Your Ref :
Our Ref : AL/30/14/NMA

Application for a non-material amendment following a grant of planning permission AL/28/12 - relating to internal layouts to provide 3No. Units in place of 4 & form mezzanine floors in each unit, also amendments to elevations (additional large windows to South & West elevations)
West Barn, Old Dairy Lane, Norton, Aldingbourne

Project			Conversion of existing barn at New House Farm, Norton Lane, Aldingbourne	
Drawing			Floor Plans	
scale	1:100	Date	Jan 2014	Drawing No 11 / 53 / 20
Drawn		Checked

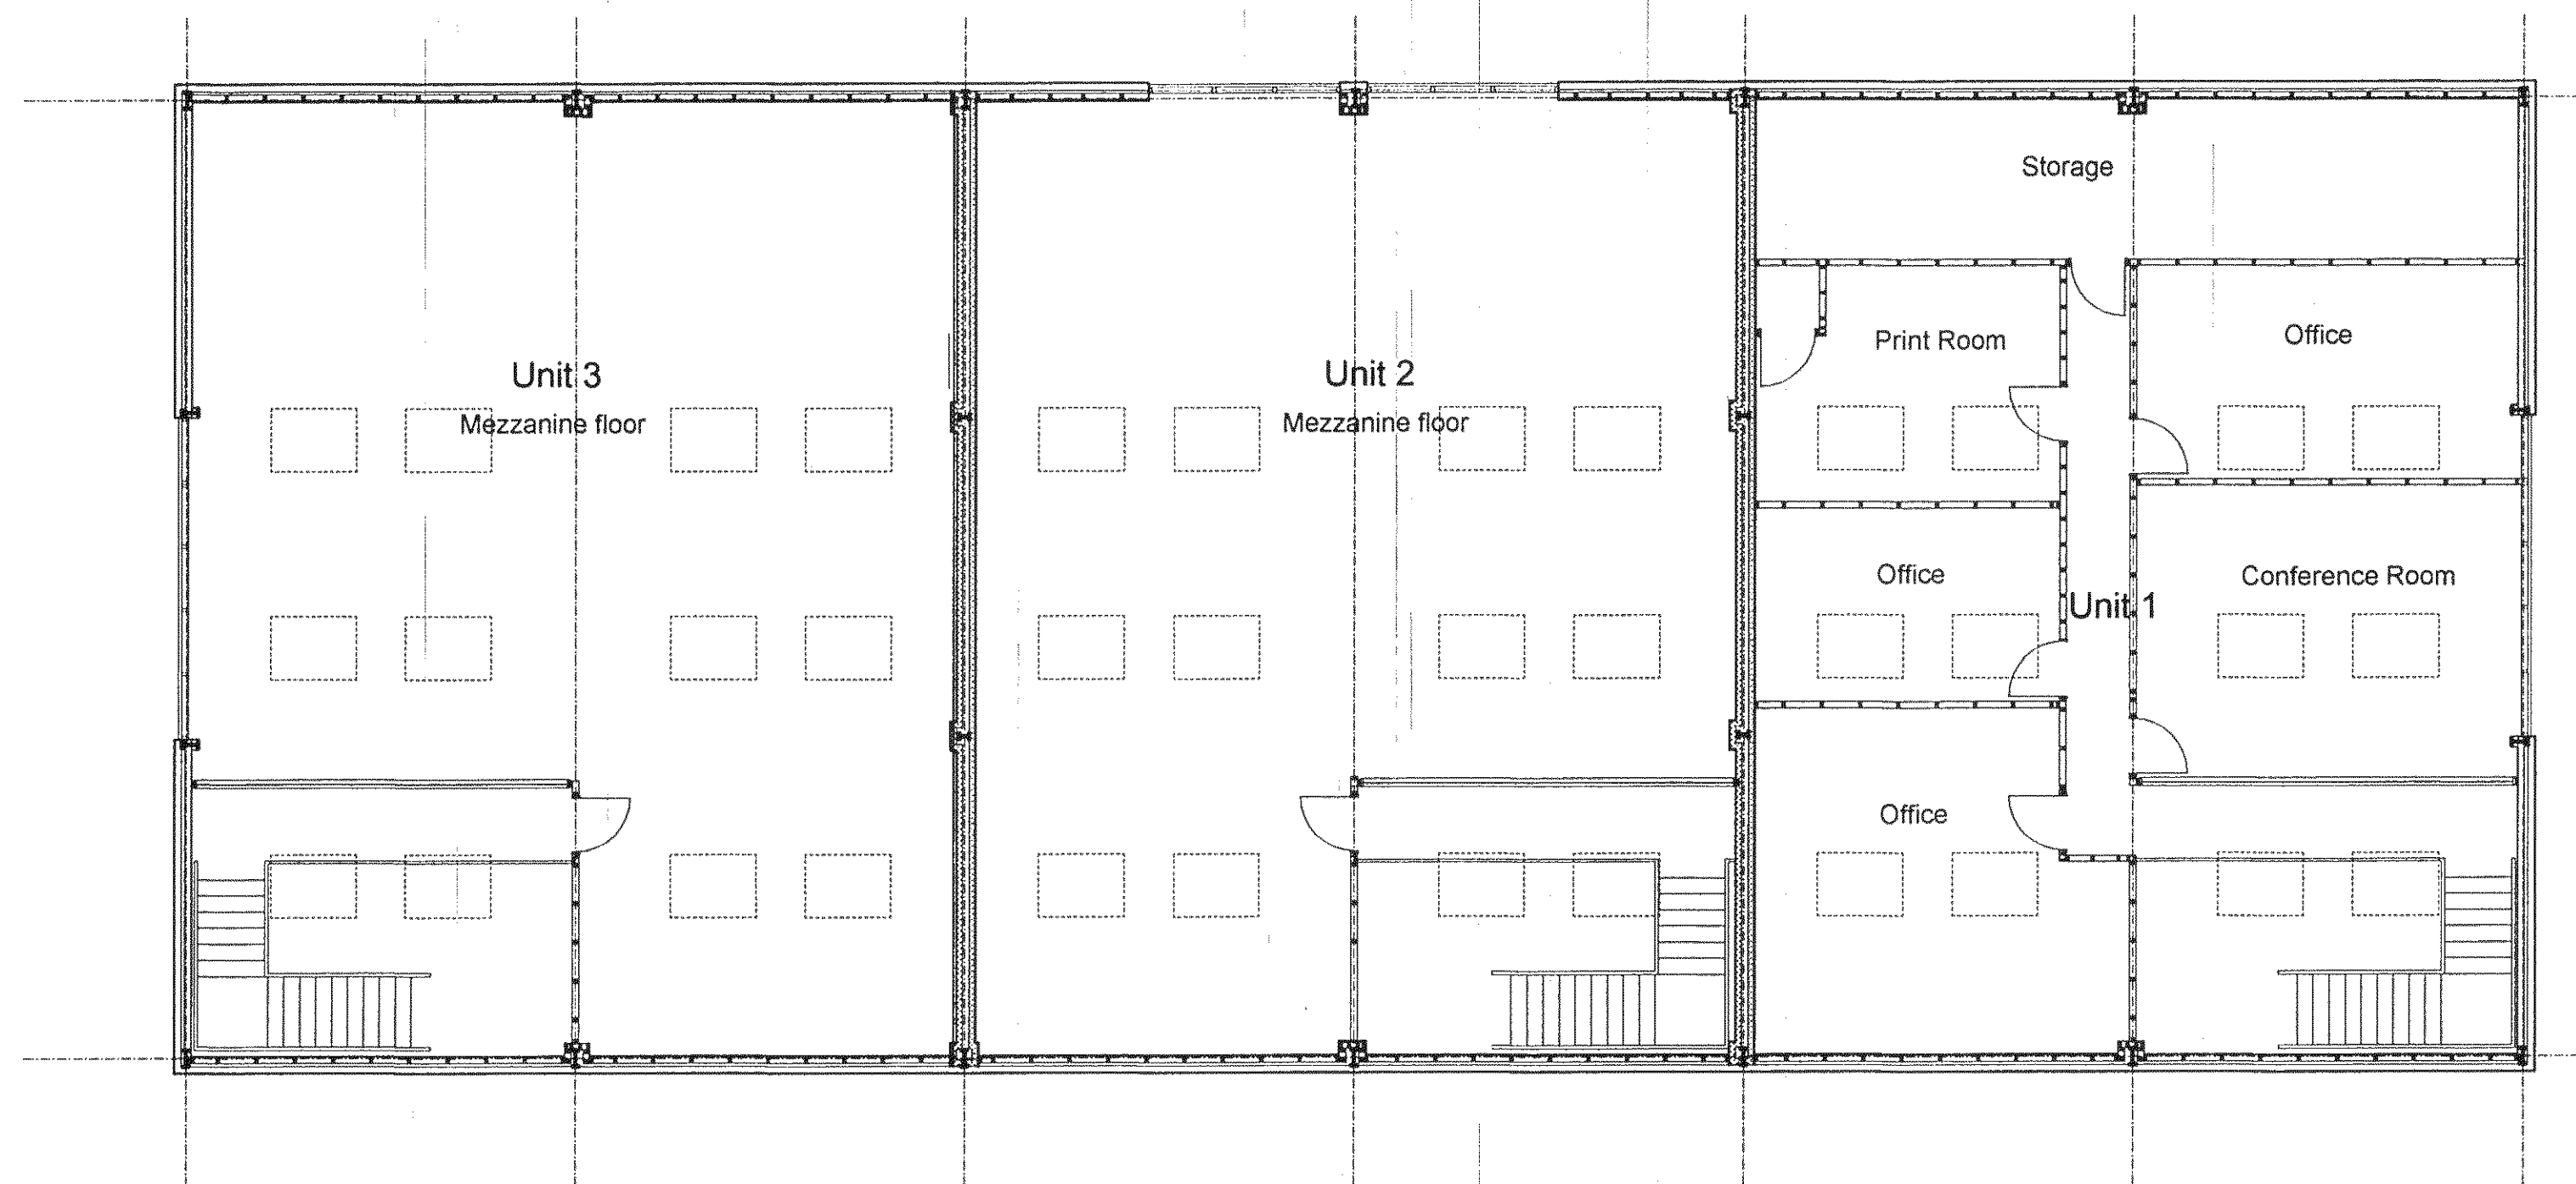
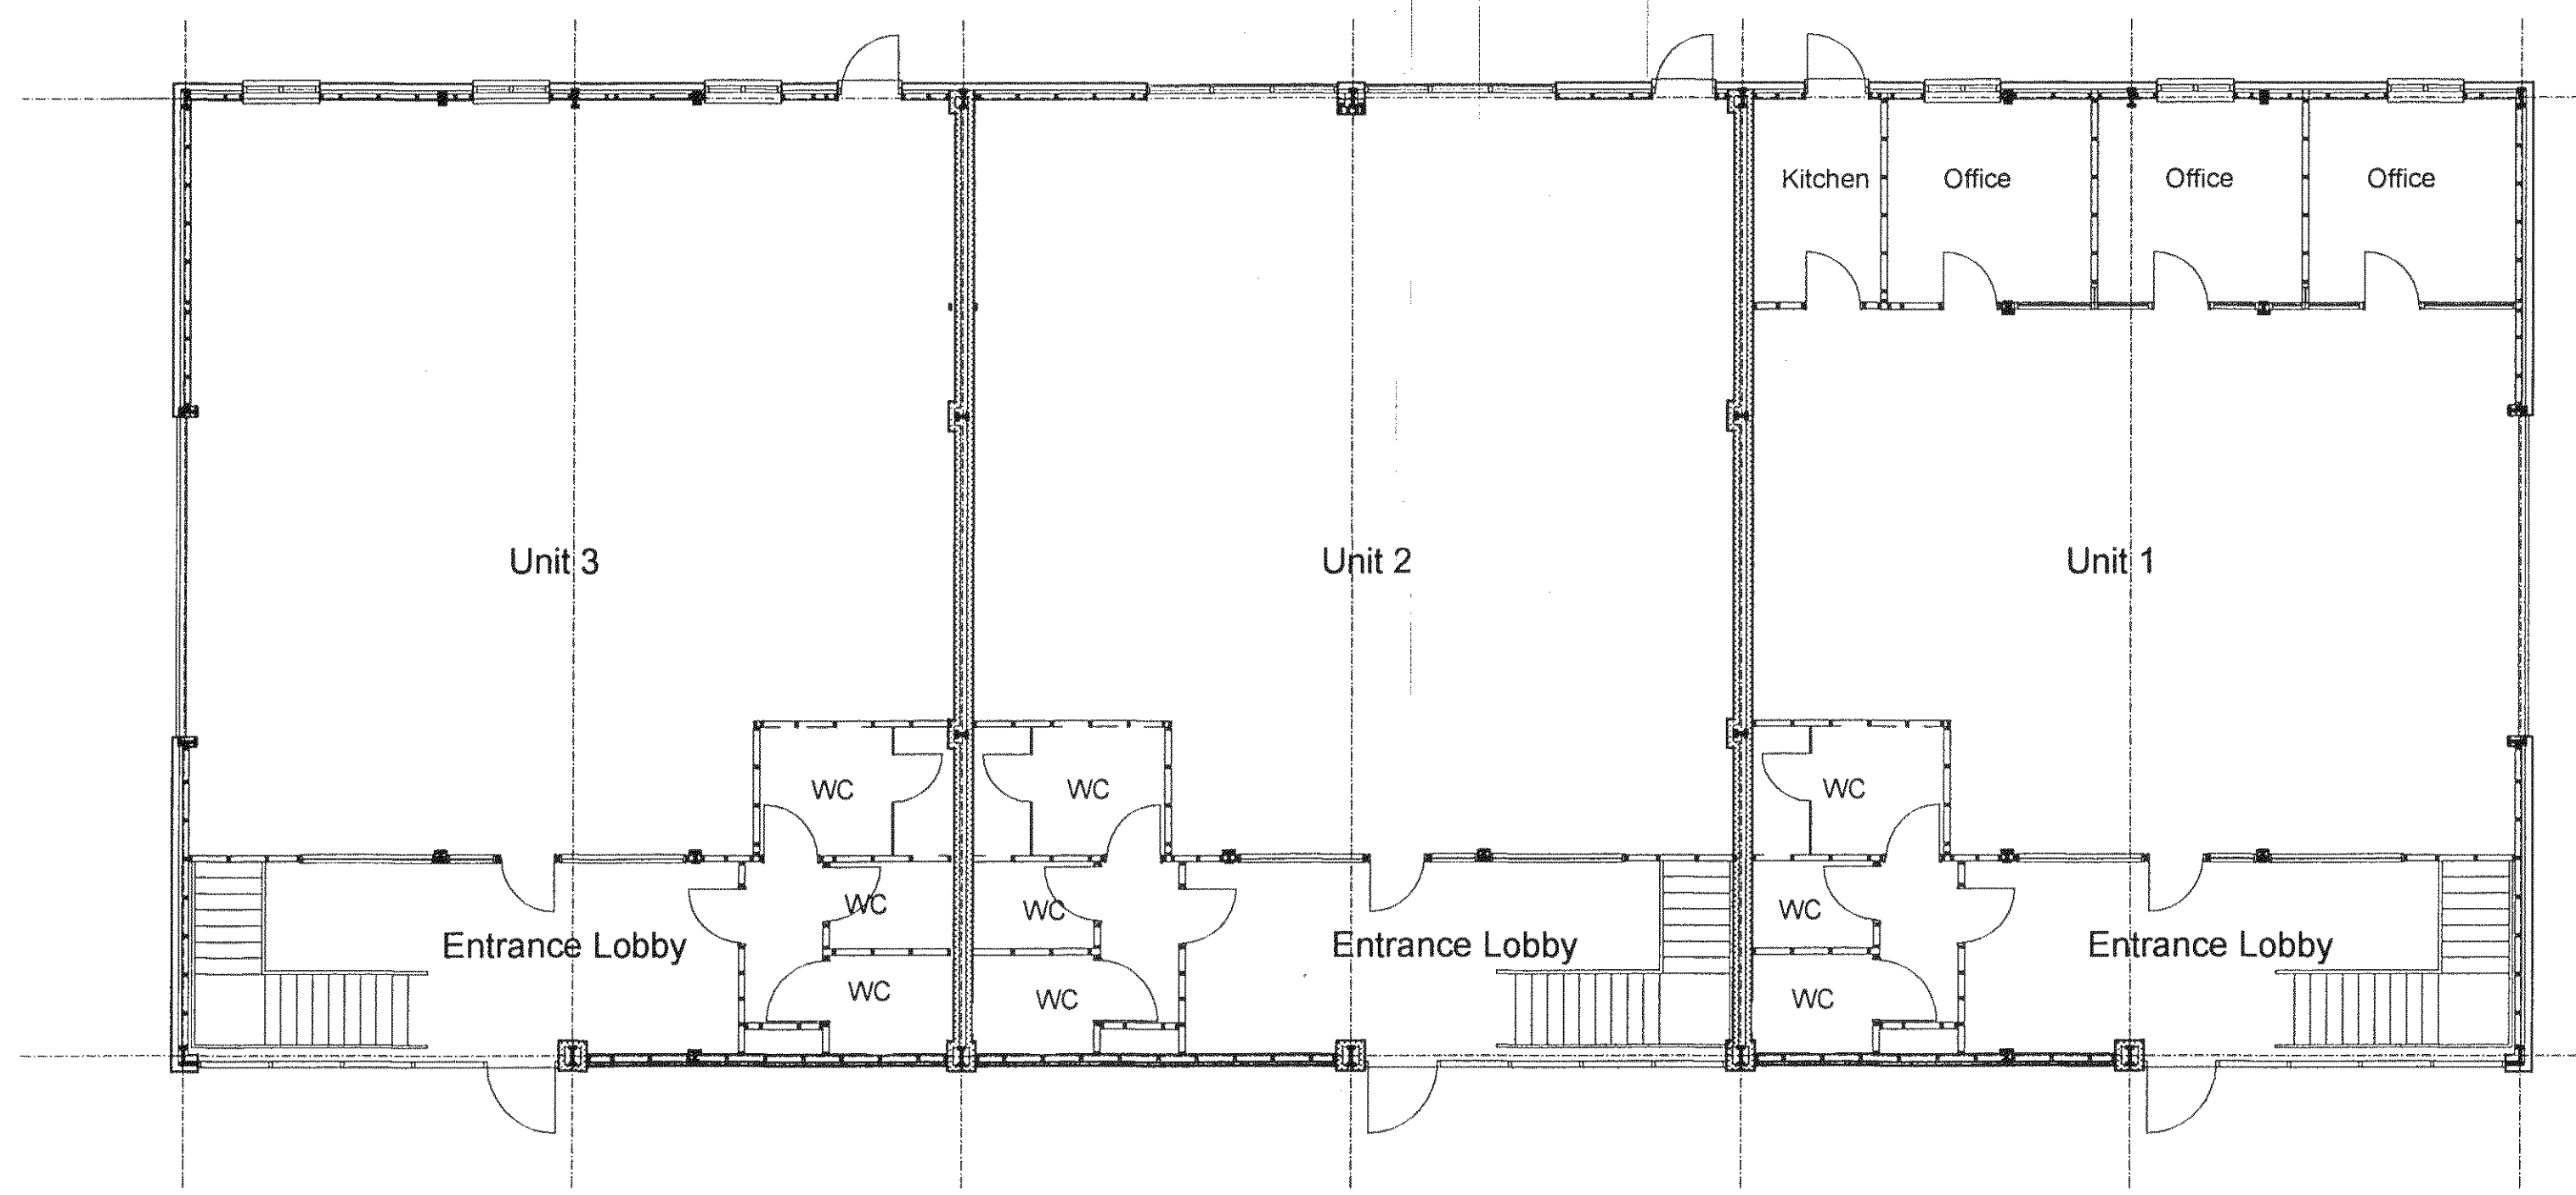
I refer to your recent application for a non-material minor amendment received on 30 April 2014 and relating to planning permission Ref AL/28/12. The plans submitted show amendments to the internal layout of the building to form three units instead of the four approved. This includes a new mezzanine floor within units 2 & 3. In addition, there are some external alterations including new glazed openings and the removal of certain approved small windows and doors in the south and west elevations. The only change to the east elevation (which faces the neighbours) is the removal of a large window.

I consider that there will be no greater harm to the neighbours as a result of this amendment and I therefore consider that the changes are not sufficiently significant so as to warrant a fresh application and that the amendment is capable of being a minor amendment to application ref AL/28/12.
